Address: 100 Skylark Rd
(lot 15 of Skylark Commons Subdivision)

C-B-L: 349-I-003
permit # 2014-01056

CHECK-LIST AGAINST ZONING ORDINANCE

Proposed Use/Work - build new single family - footprint 28' x 31' (includes porch & deck)
get two stories (garage in front } full 2.5 story in back)

RIGHT ELEVATION
Scale: 1/4" = 1'-0"

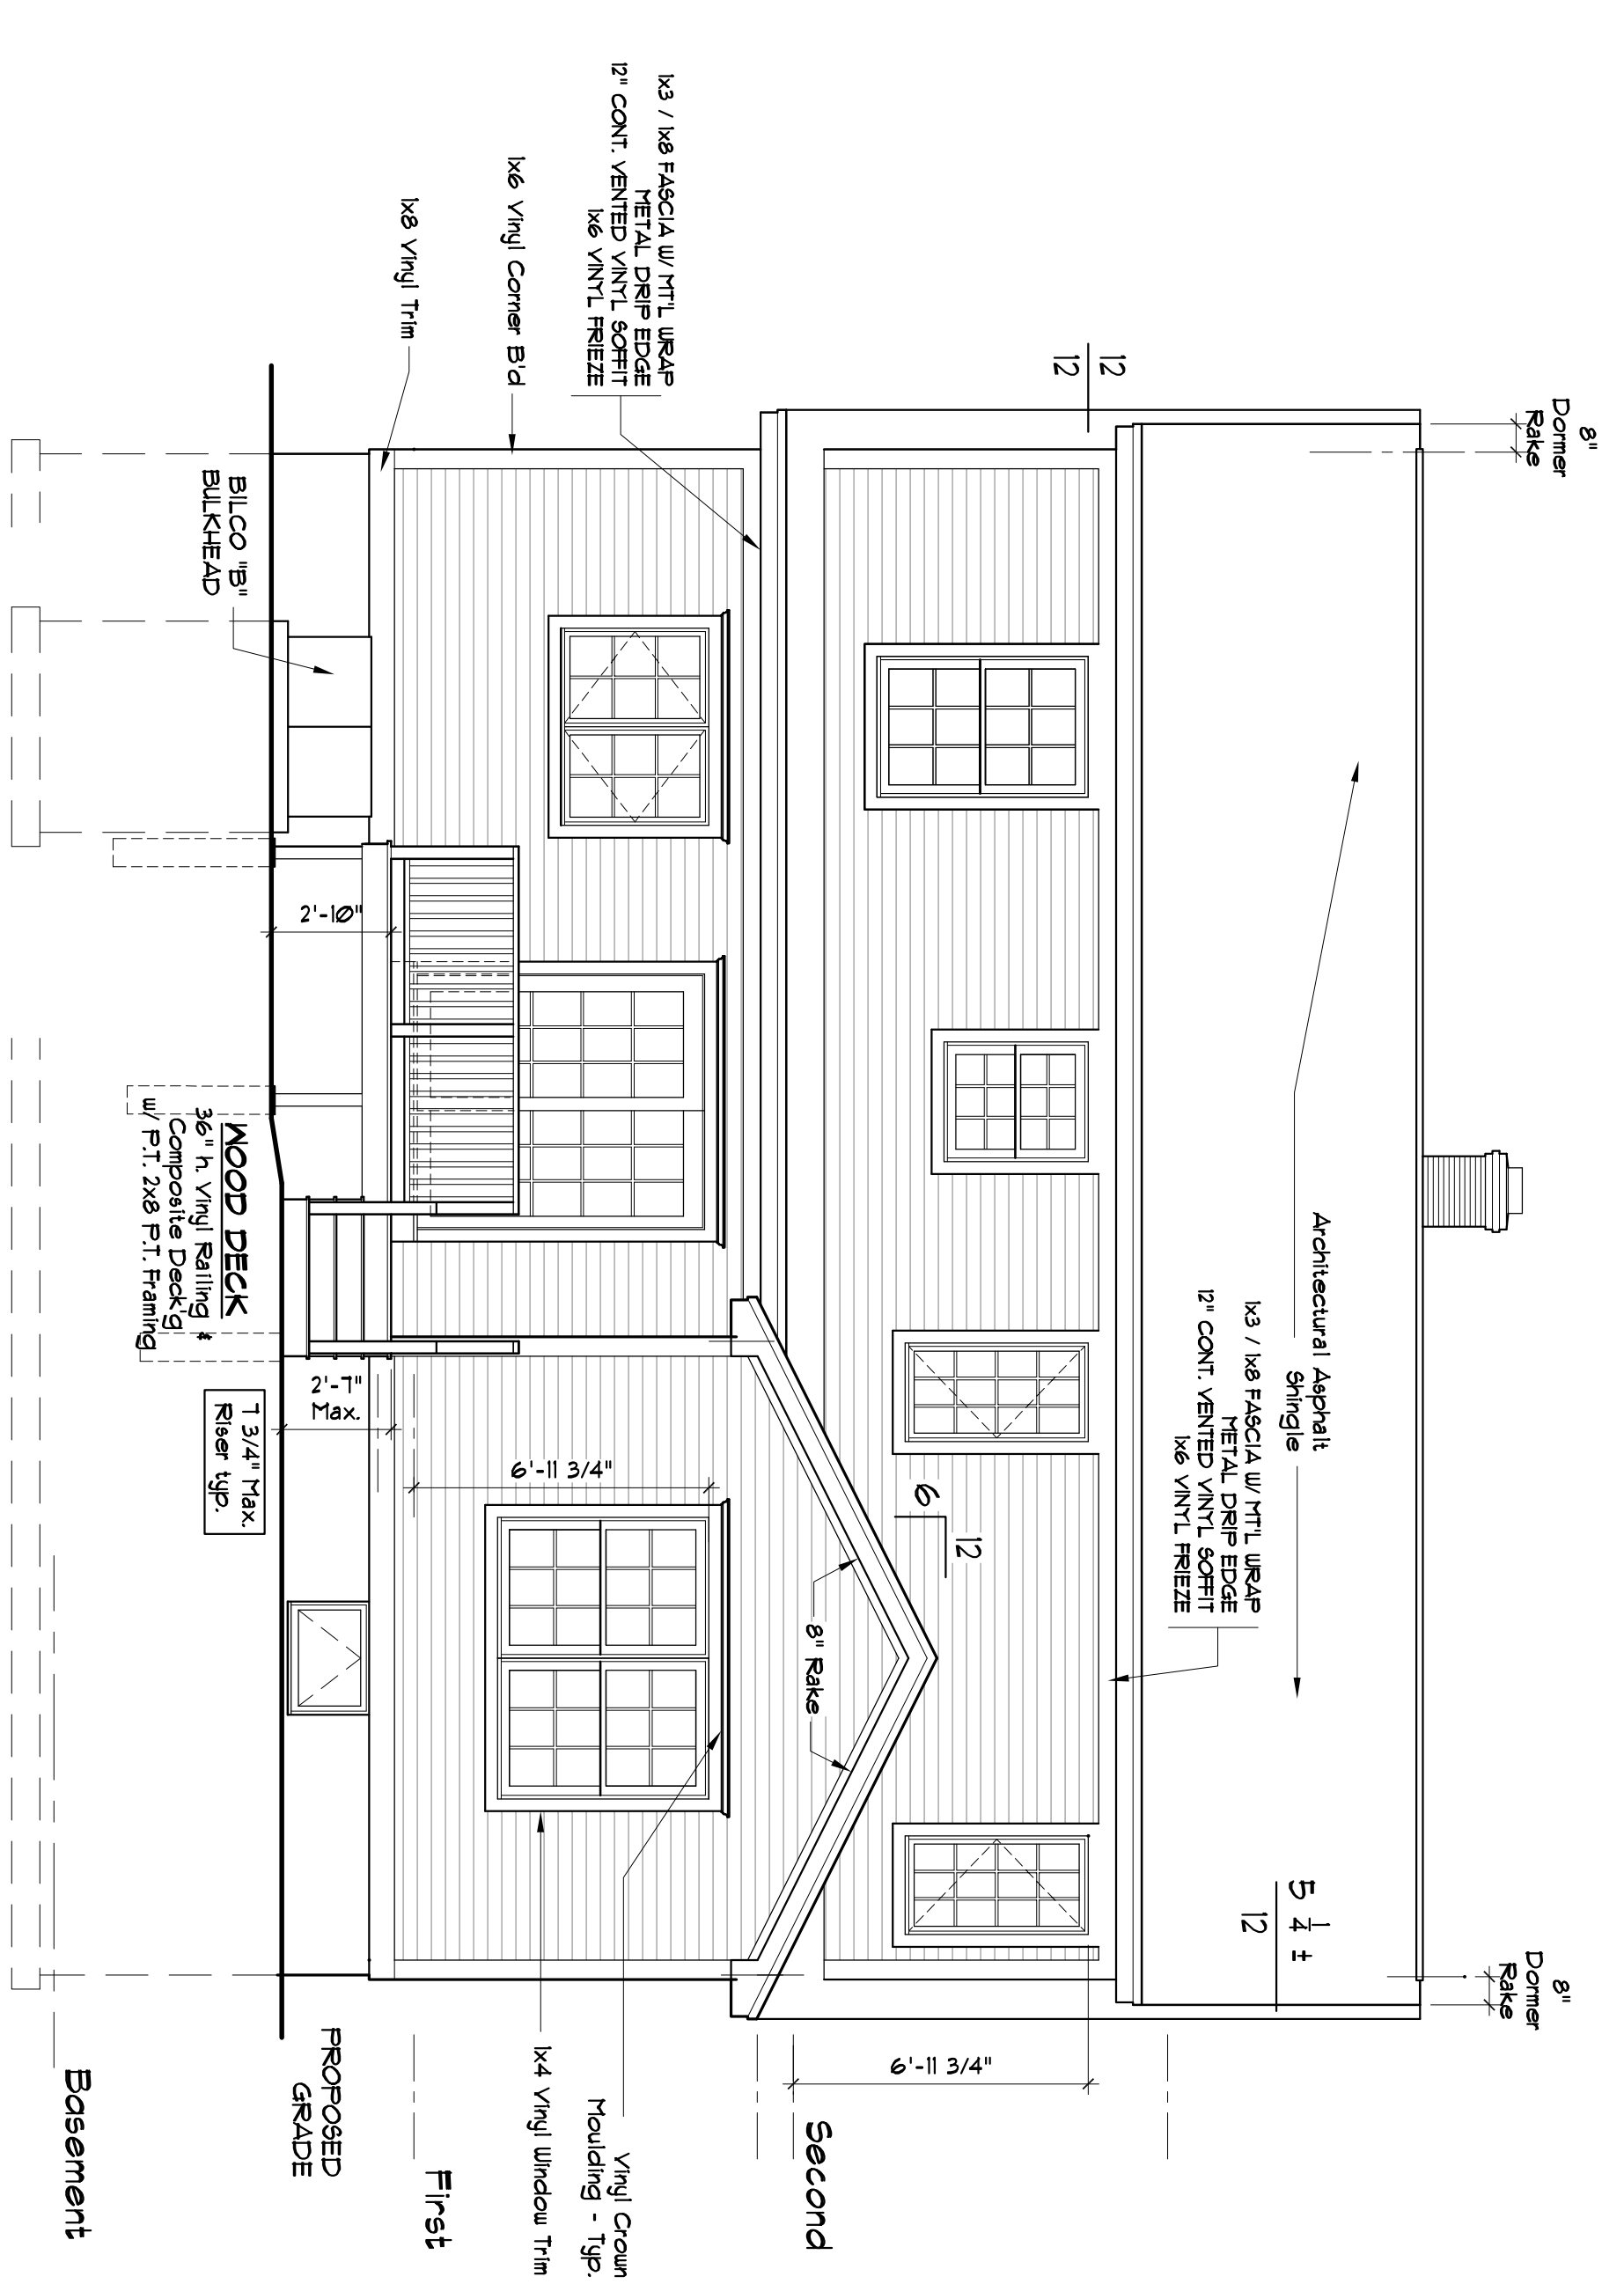
Height - 35' max - 27' from lowest grade bridge (OK)

SITE PLAN-LOT 15

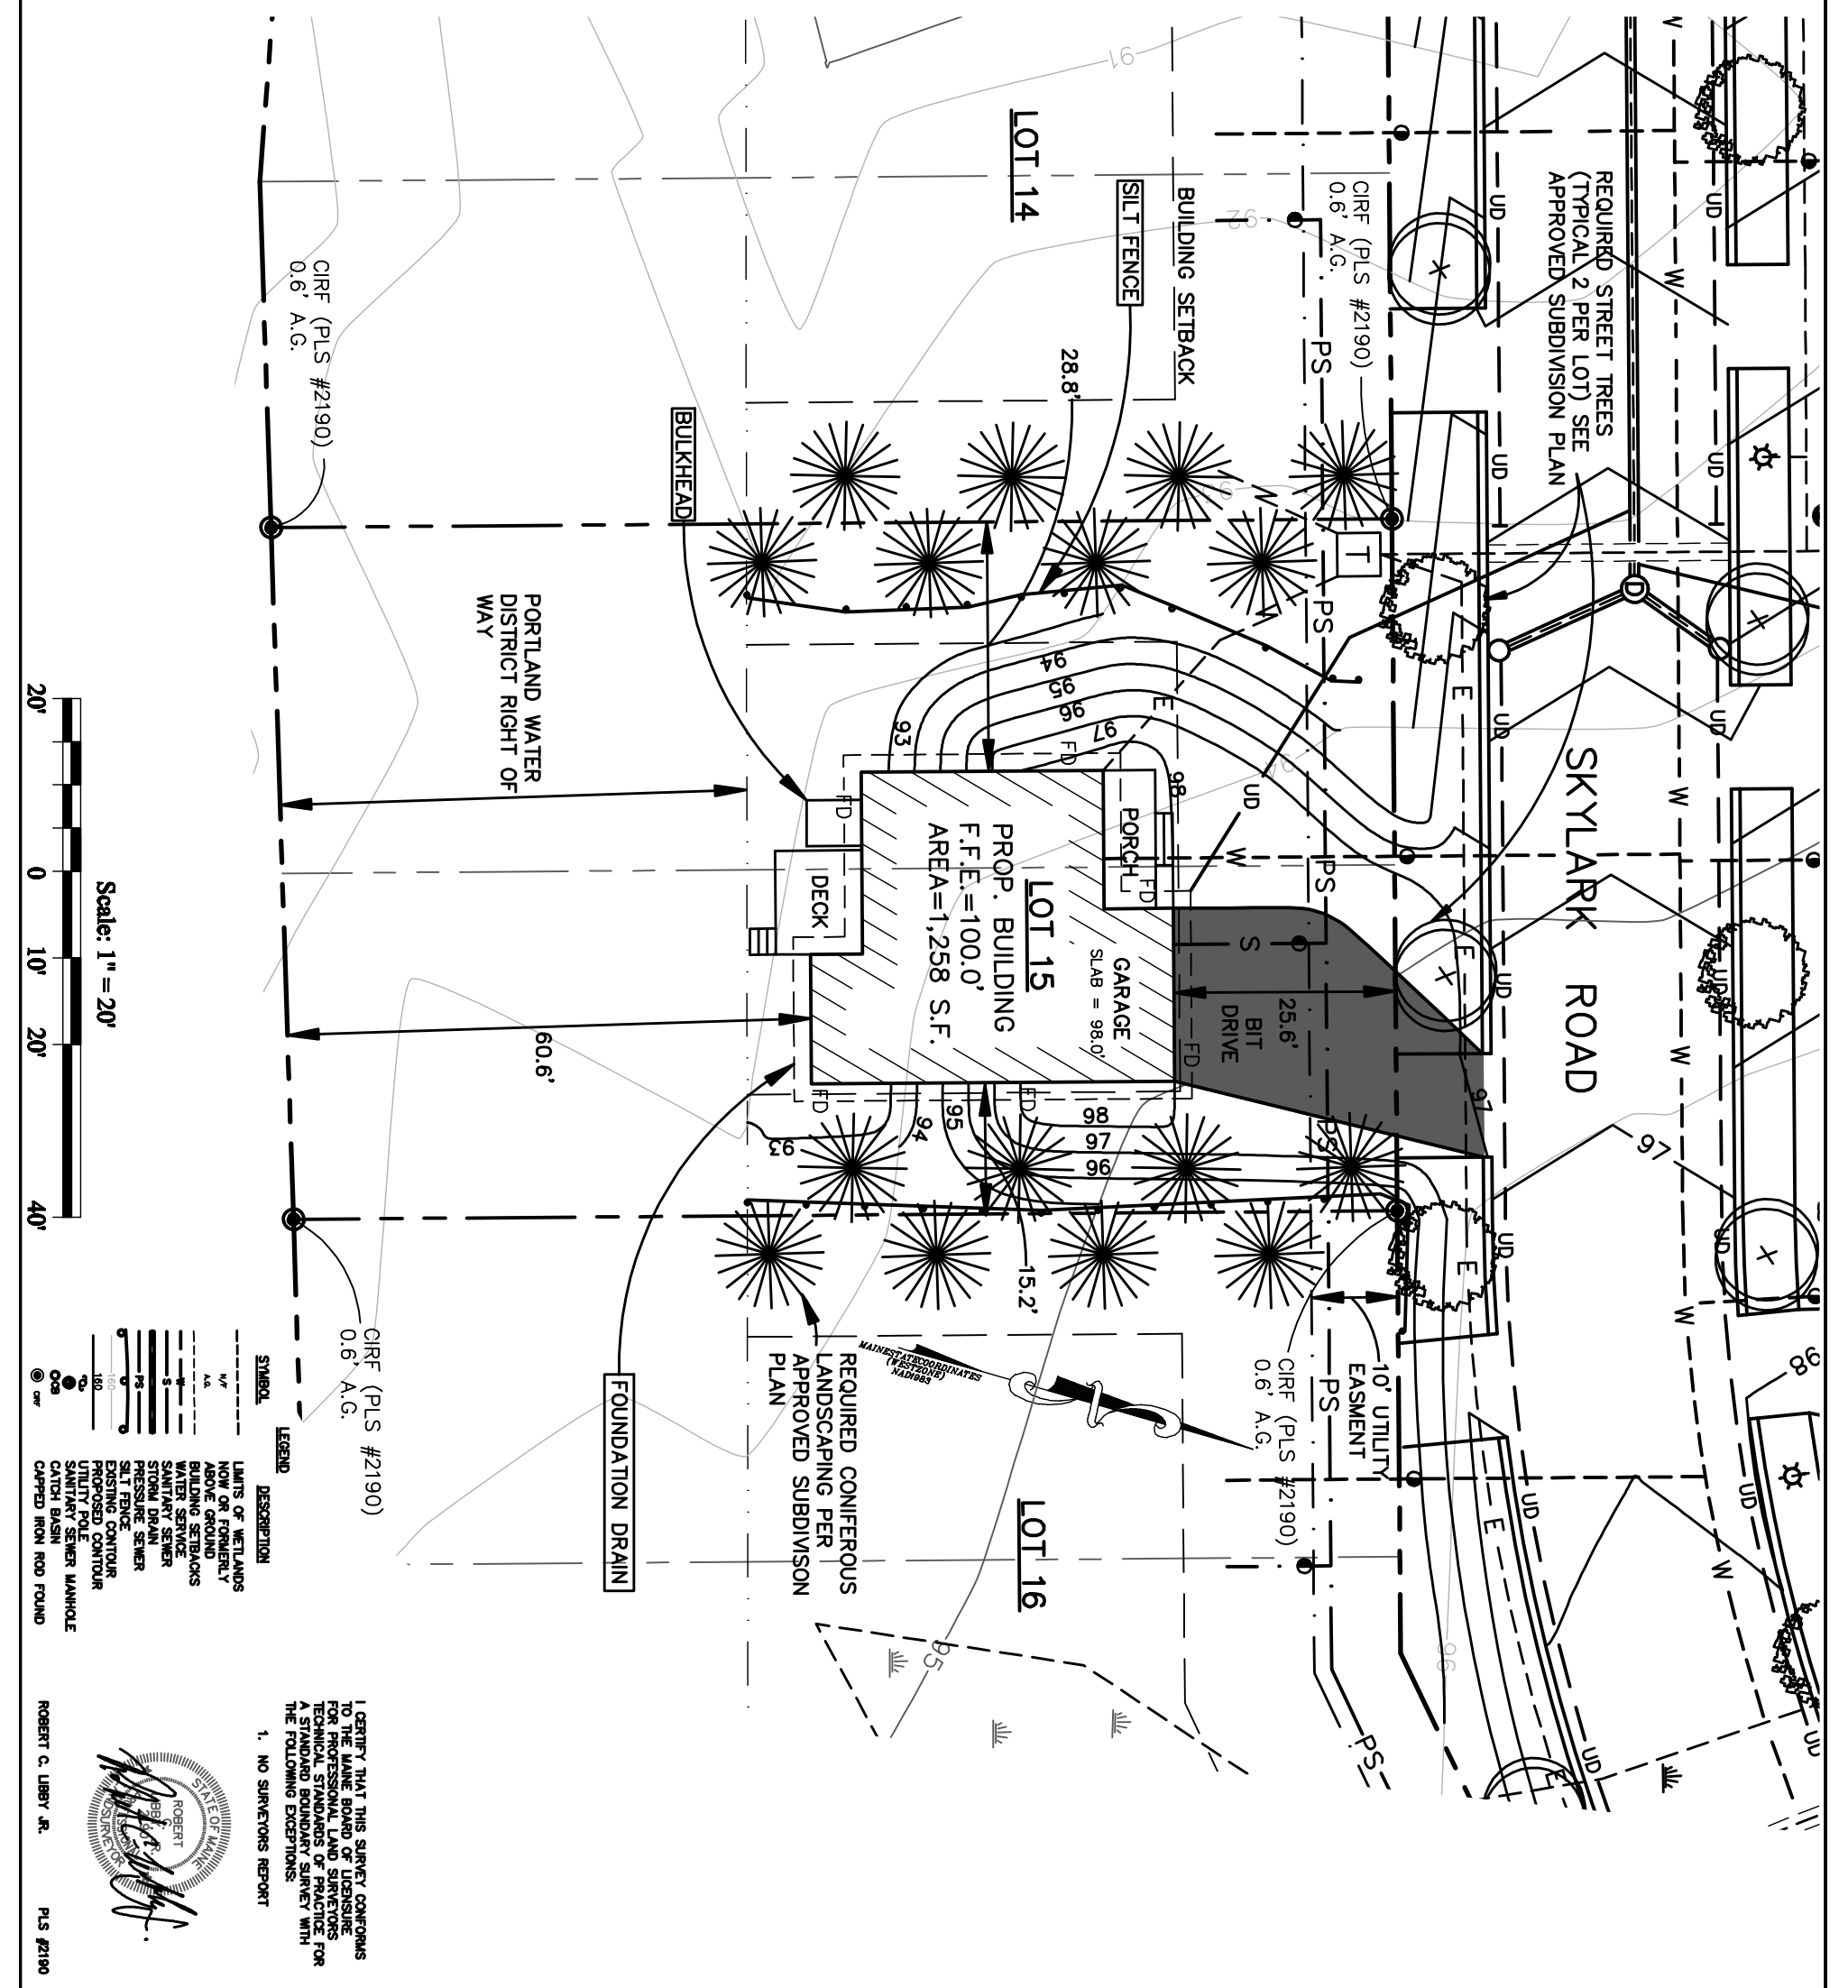
Lot Street Frontage - 50' min. - 80' on amended sub division (OK)

Front Yard - 25' min - 25.5' given (OK)

Rear Yard - 25' min - 53.77' to deck steps (OK)

Projections - 25' high - 14' min - 28' scaled on right (frustrated) 15' scaled on left (frustrated)
deck 10x12 + bulkhead 6.5x8; porch 6x16'

Width of Lot - 65' min - 80' scaled (OK)

Lot Area - 6500 sq ft min - 10,240 sq ft given (OK)

Lot Coverage Impervious Surface - 35% = 3,601.5 sq ft
